Simon Skelton

September 2023

### SUMMARY

This report demonstrates the significant impact of the Cottam Solar Project on our family home and our way of life.

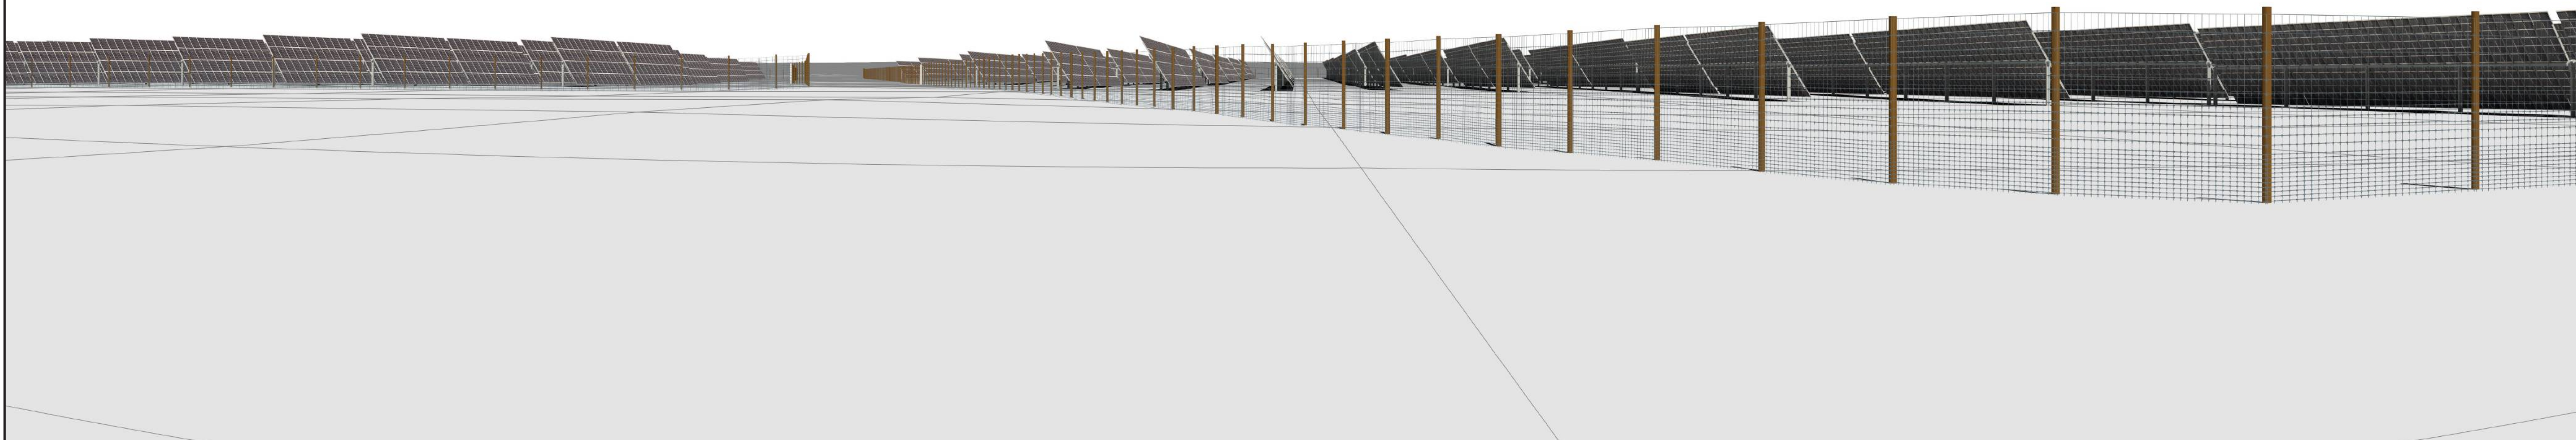
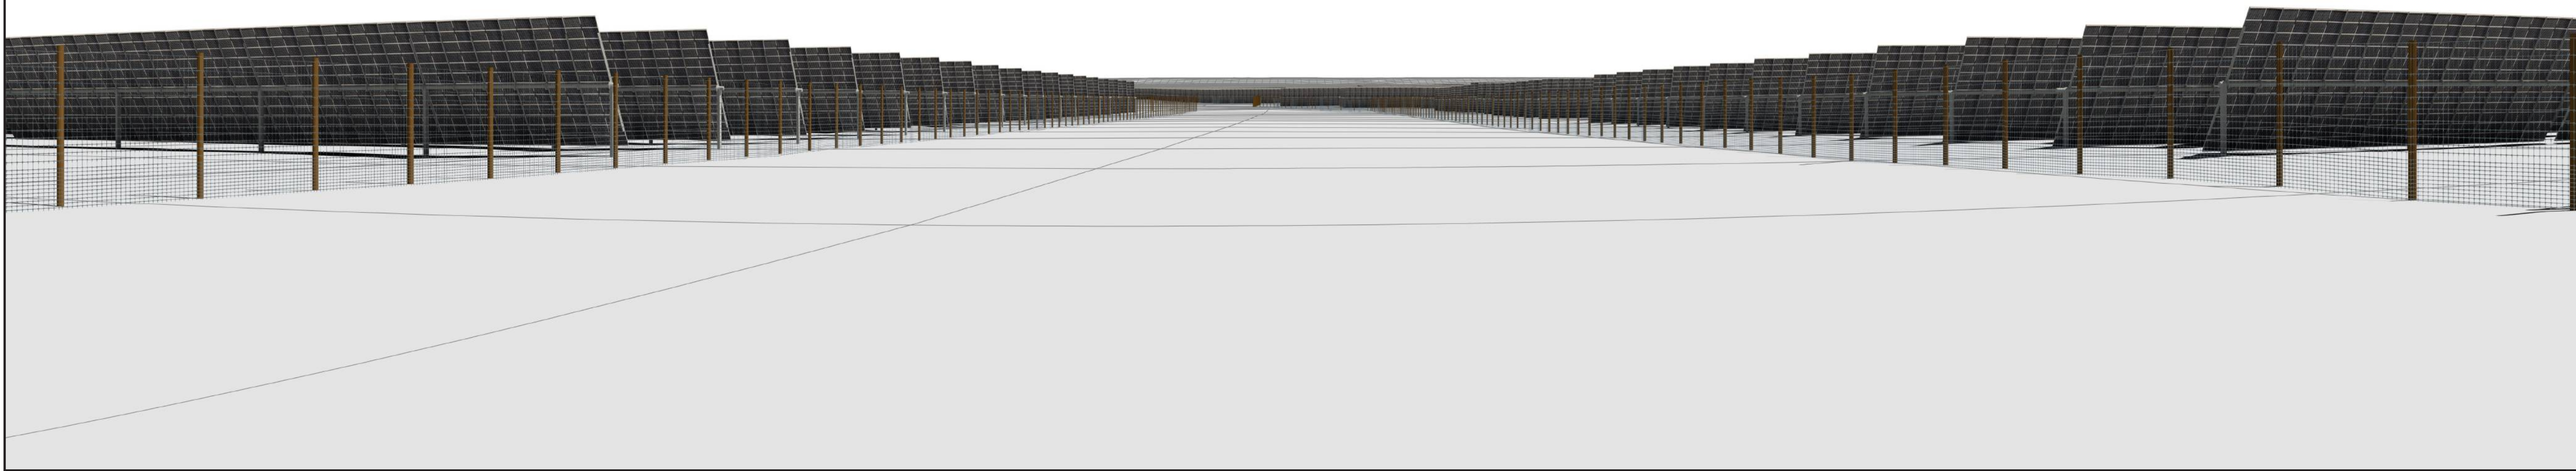
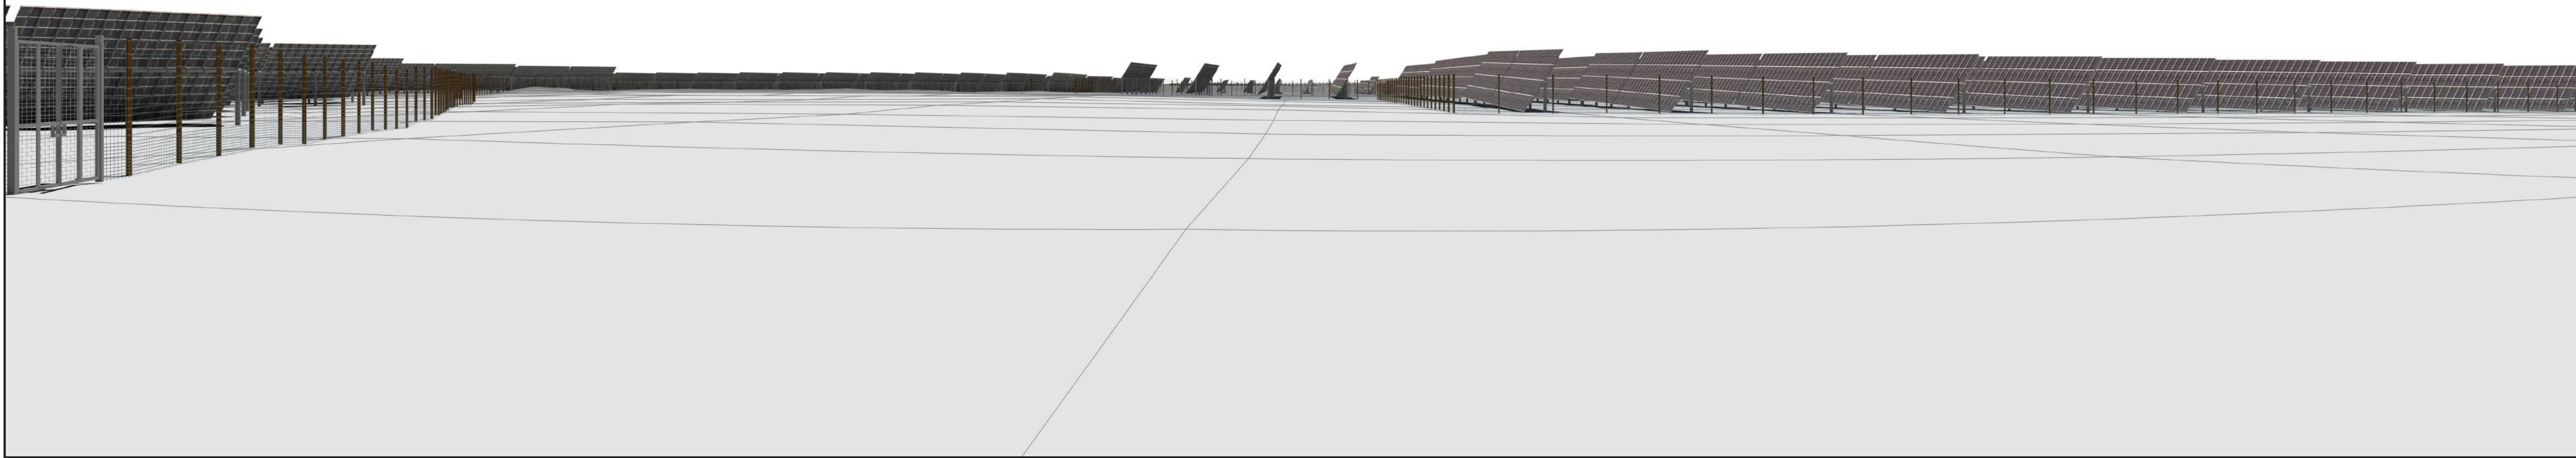
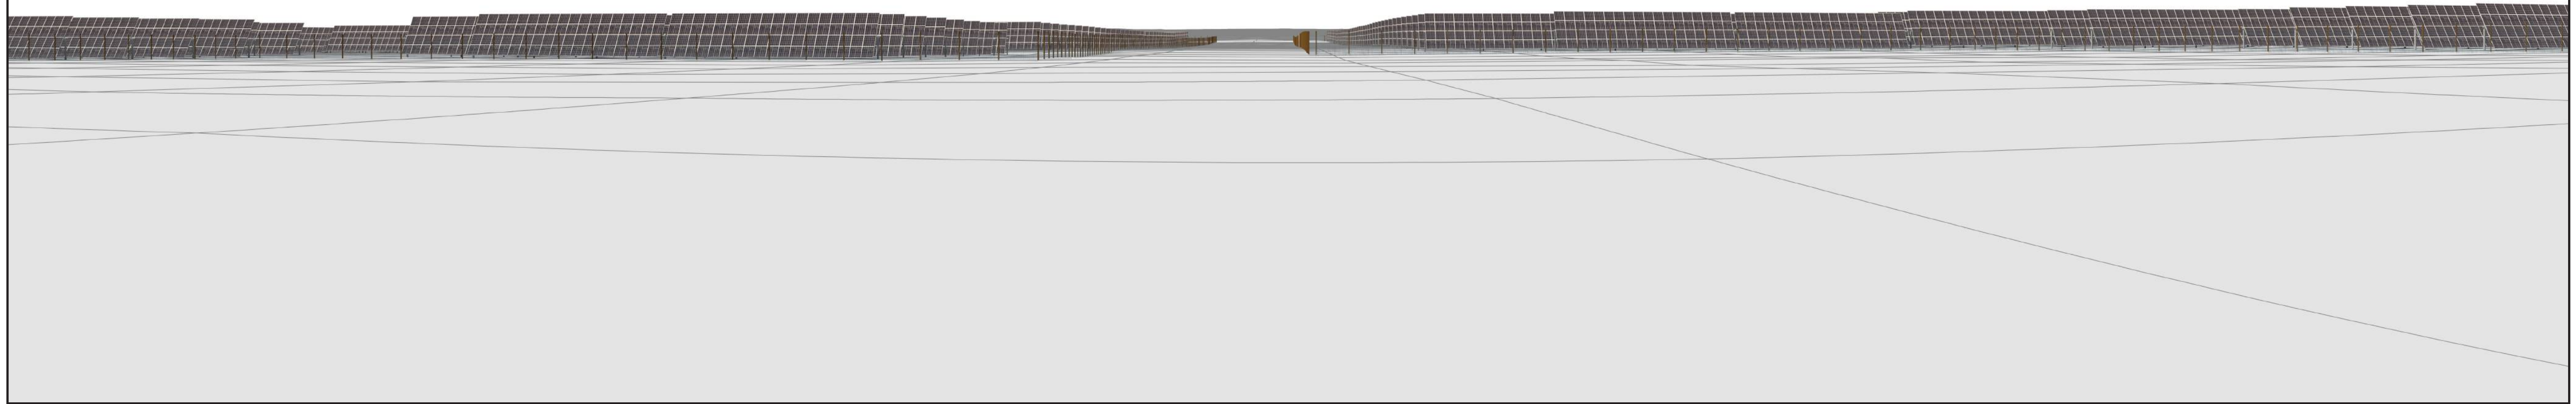
Above. C6.4.8.14.76 Figure 8.14.76 LCC-C-I Viewpoint 76 Photography Photomontage (image 10) **supposedly** showing 4.5 metre high tilting solar panels, facing east.

Below. Is myself with a 4.5 metre gauge stick at the same location as above, showing the true proposed panel height and the immense impact and unsuitability of their size in a countryside location.

It is disturbing that IGP are again misleading the public and indeed the Examining Authority by publishing these shameful photomontages, showing significant deception over panel height. I do not believe any of the photomontages to be accurately scaled!
